Subject: AB/28/26/PL

Address: First Floor Flat 5-7 High Street Arundel BN18 9AD

Proposal: Replacement Windows and removal of a rooflight.

South East and West Elevations Existing and Proposed

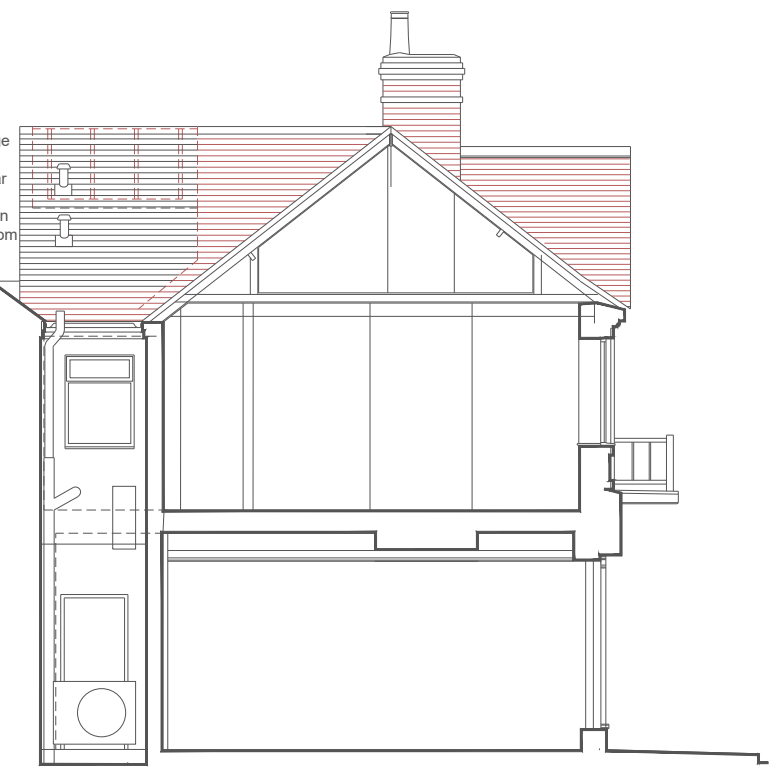
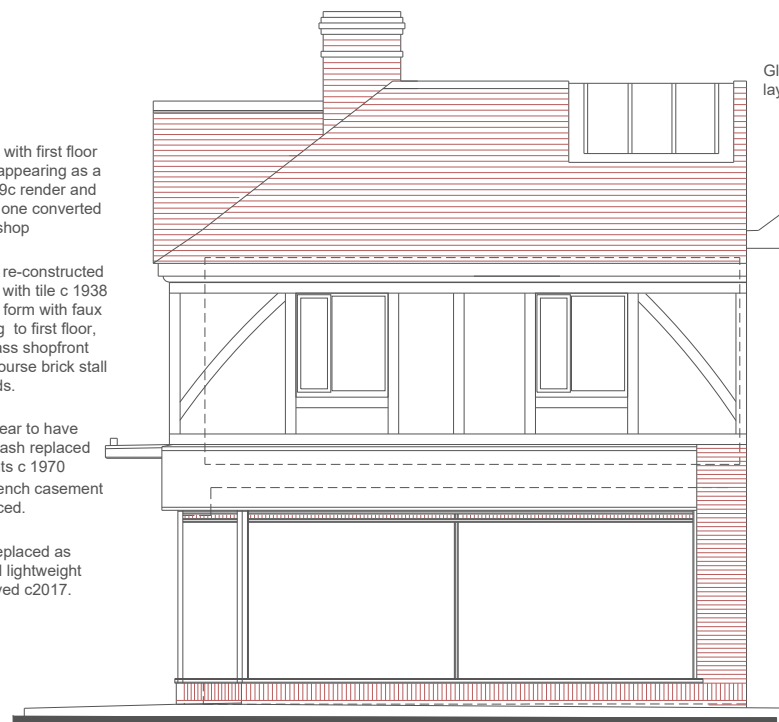
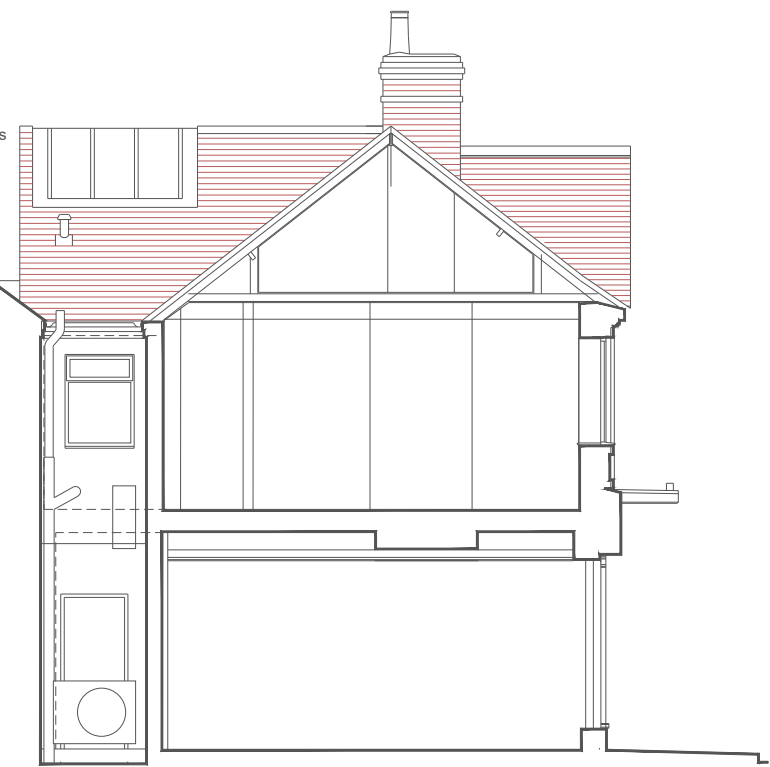
Whilst the intention to improve the building is positive, the design of the windows as proposed is not acceptable and would still result in harm. The original windows, removed in the 1970s, were vertically sliding sashes which reflected the intended character of the building.

The proposed replacements attempt to give the appearance of sash windows when closed, but they are in fact top-hung casements which open out as a single unit. Such windows lack the subtlety of traditional vertically sliding sashes, and when open it would be obvious that they were not sash windows (their true form/method of opening) would be clearly apparent. They would not enhance the appearance of the property and would instead detract from it.

This approach does not replicate the function or appearance of traditional sash windows and would appear incongruous in this highly visible and sensitive location. As such, the proposal would detract from the character of the building and fail to preserve the appearance of the conservation area.

It is important that any replacement windows are of a traditional design, appearance and method of operation. In this case they should be painted timber vertically sliding sash windows.

The removal of the rooflight is acceptable, subject to the use of appropriate replacement tiles, and would represent a minor improvement.
